Bent Grass East Commercial Filing No. 3 Traffic Impact Analysis

Prepared for:
LAND FIRST INC
1378 PROMONTORY BLUFF VW
COLORADO SPRINGS CO, 80921

NOVEMBER 13, 2020

LSC Responses to TIS Redline Comments on.. Bent Grass Commercial Update TIA REPORT

Figure 4

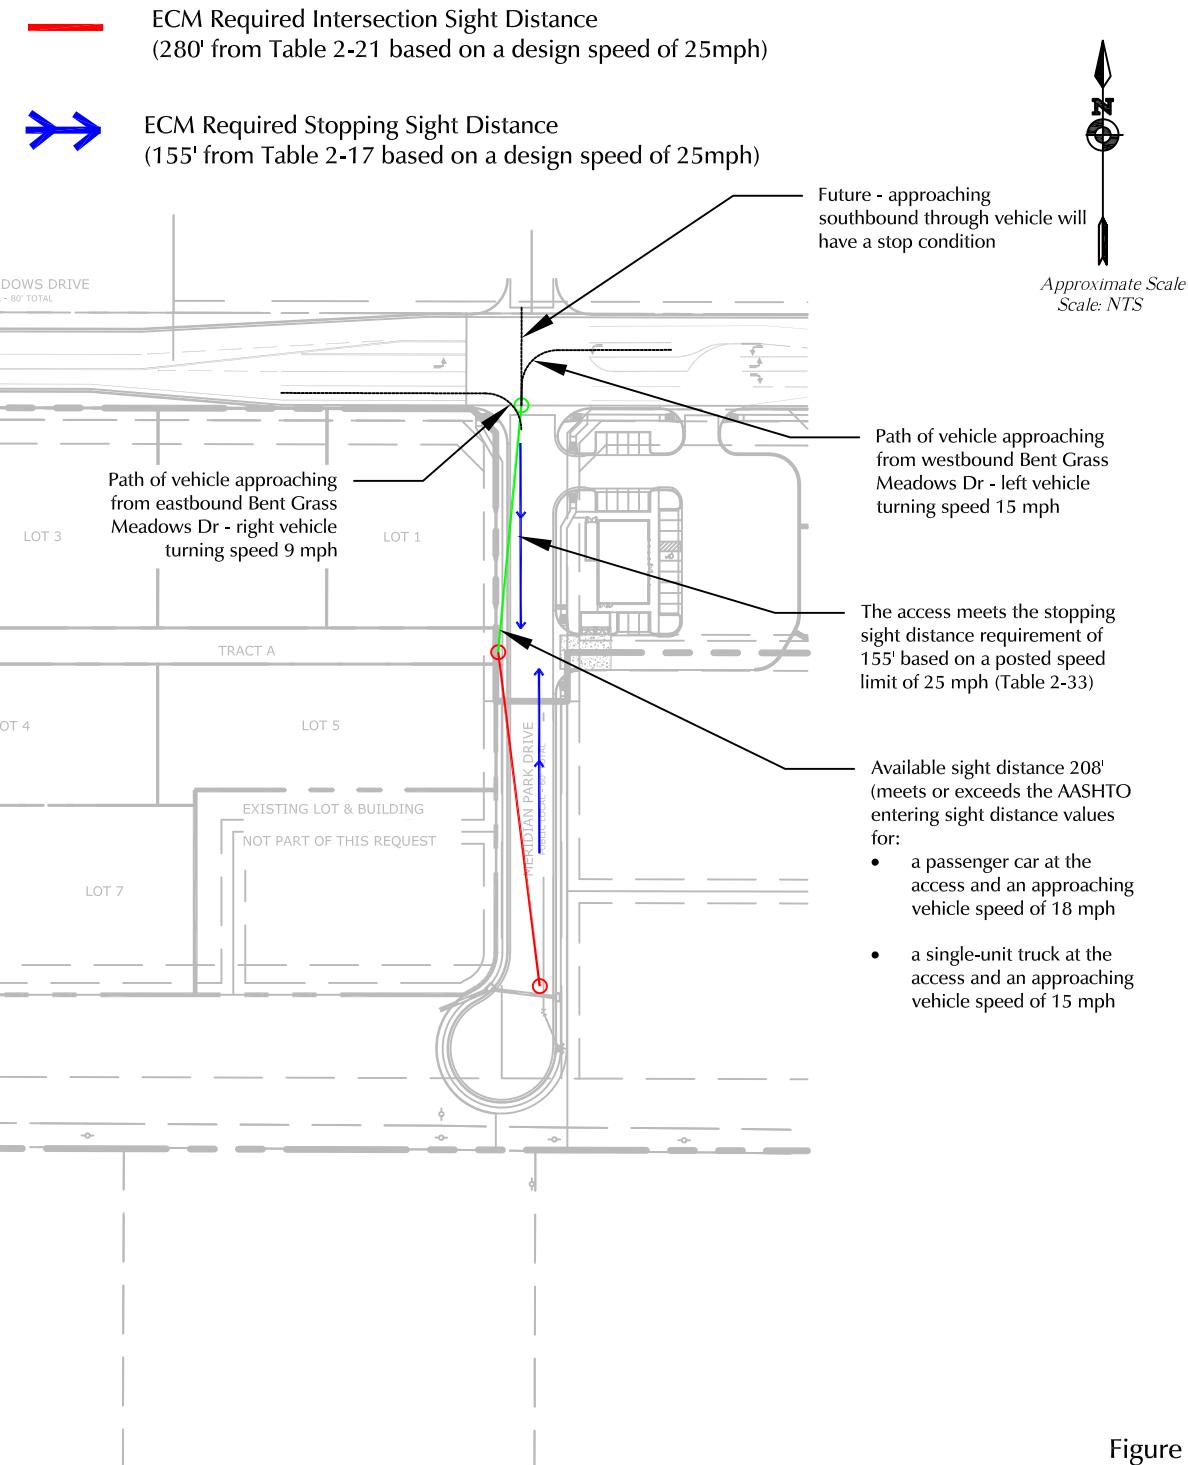
Please state whether or not the access locations meet the intersection spacing requirements in the ECM for a non-residential collector and local roadway.

Author: kdferrin Subject: Sticky Note Date: 3/5/2021 13:09:49
LSC Response: The additional information has been added to the updated TIS as requested

Figure 5

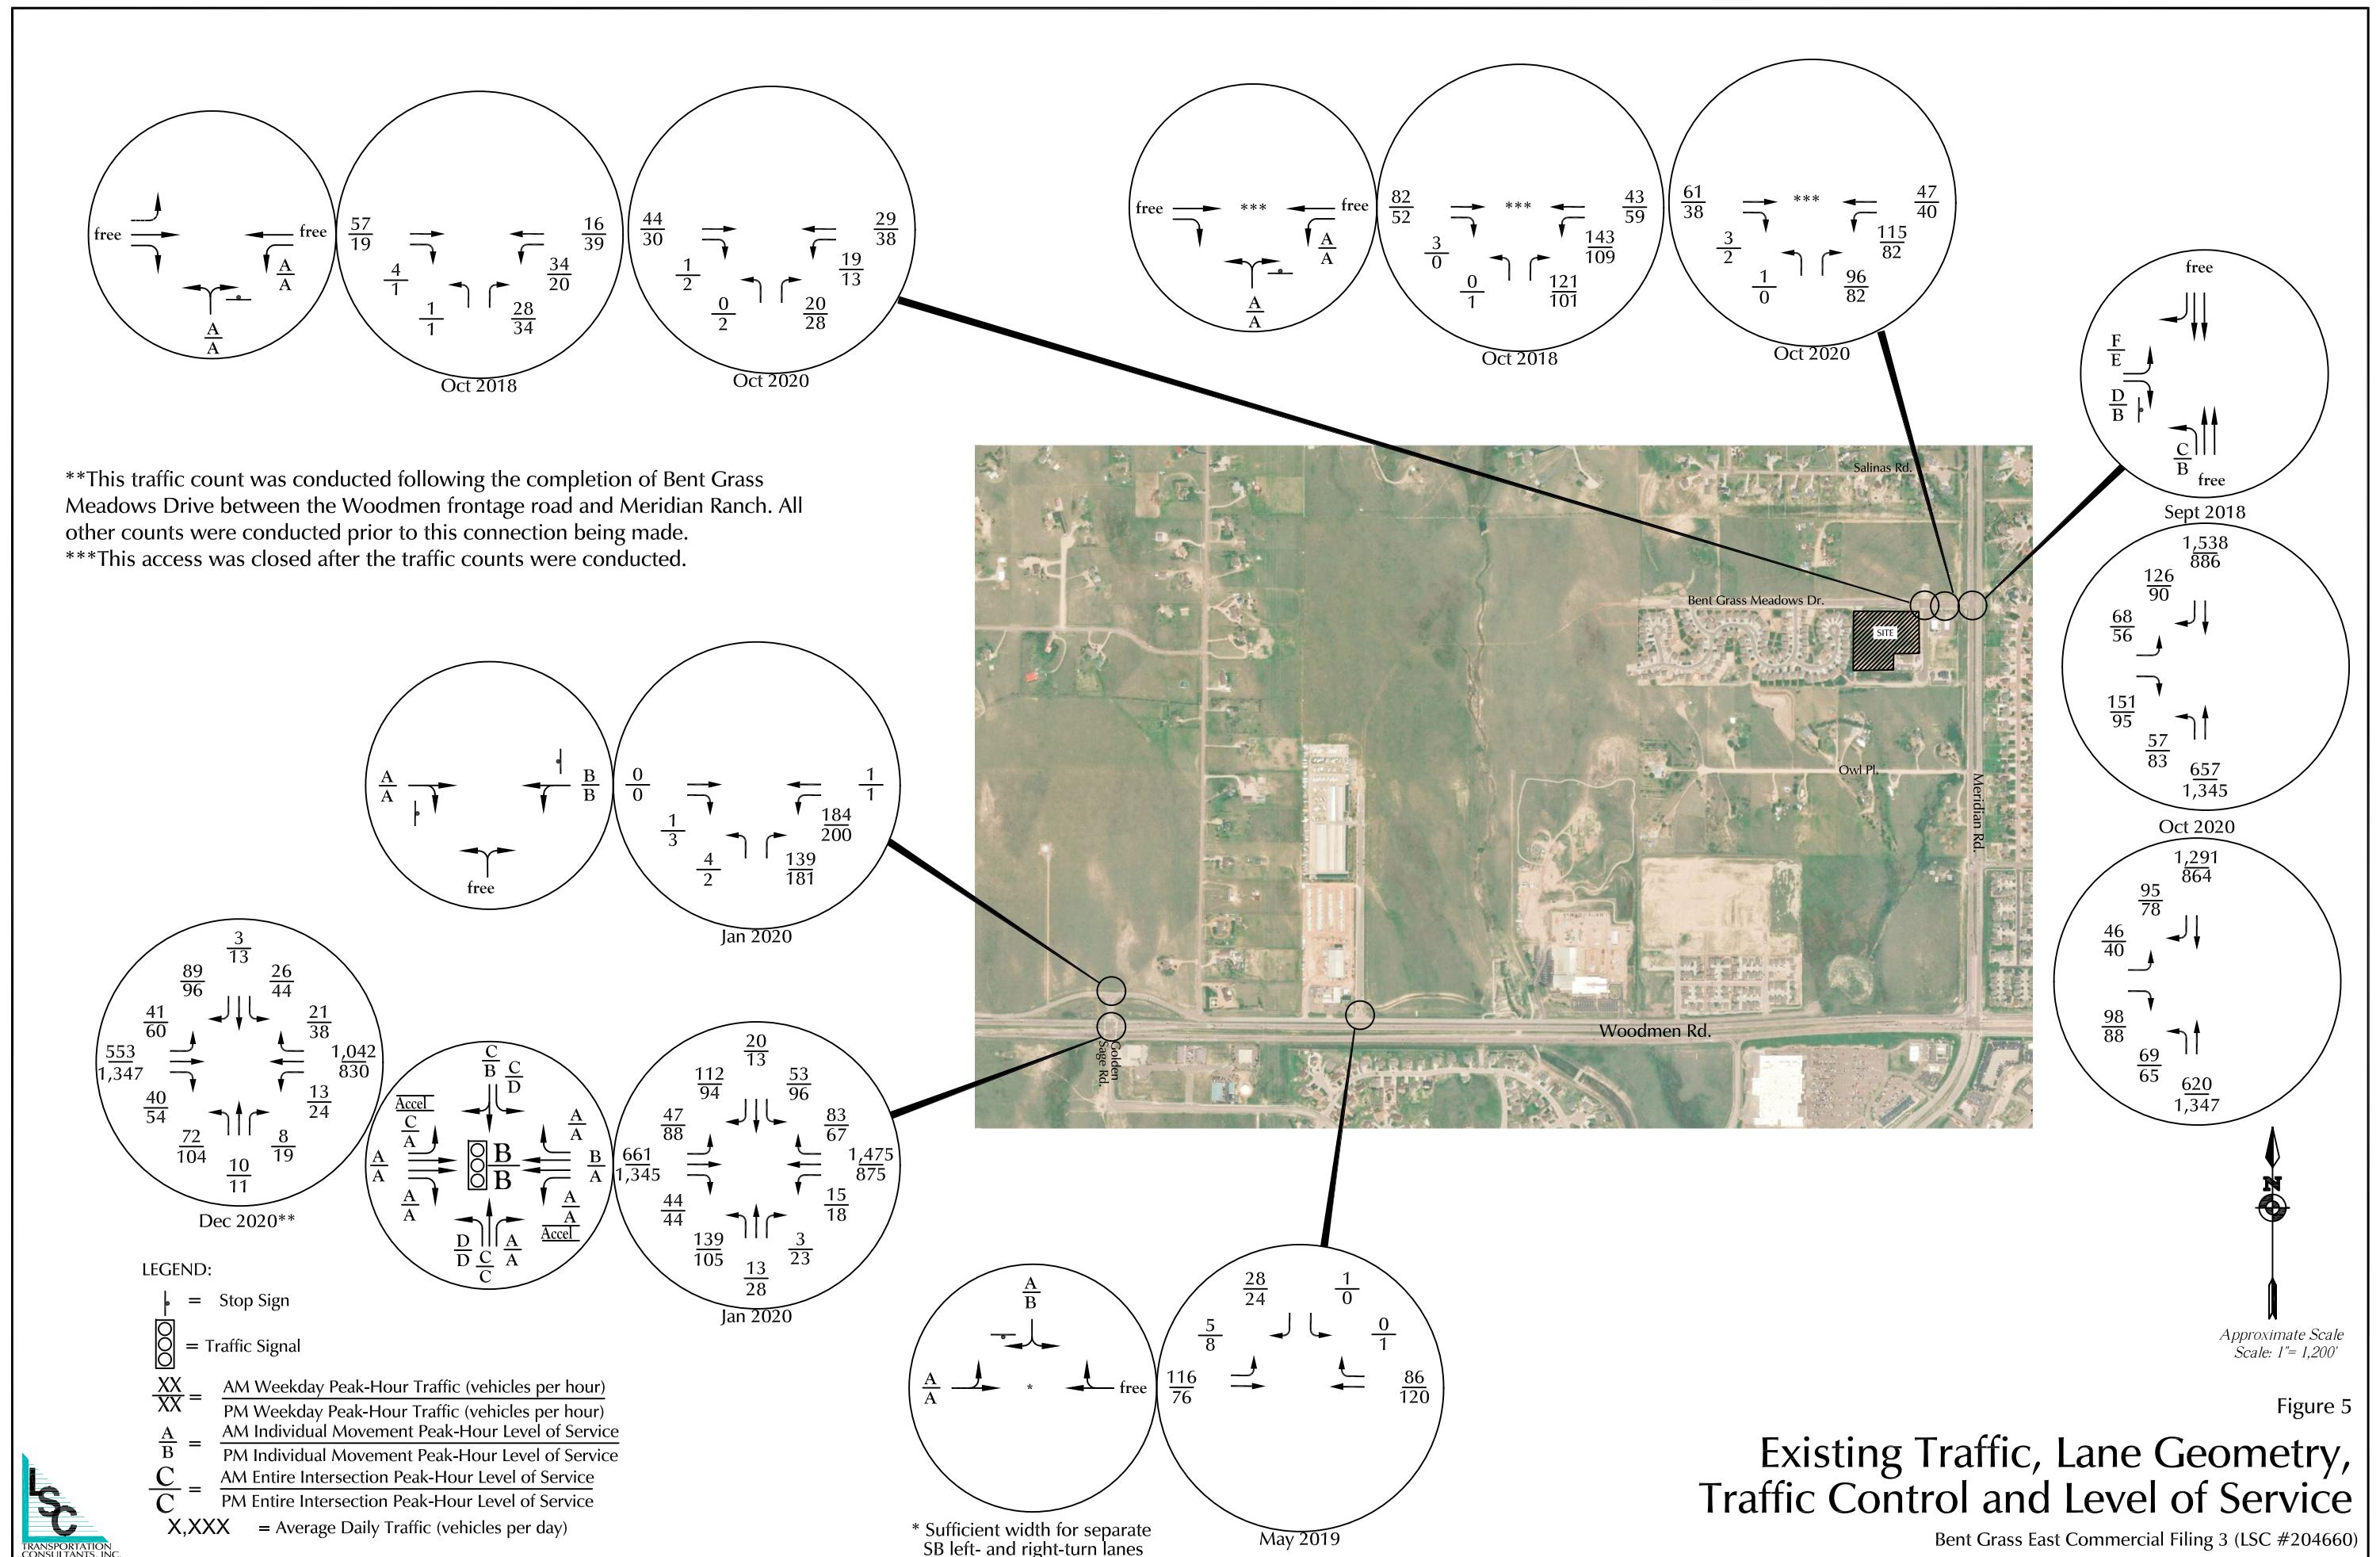
[Please see comment in figure 5.](#)

LSC Response: The most current count data has been included in the updated TIS as requested.
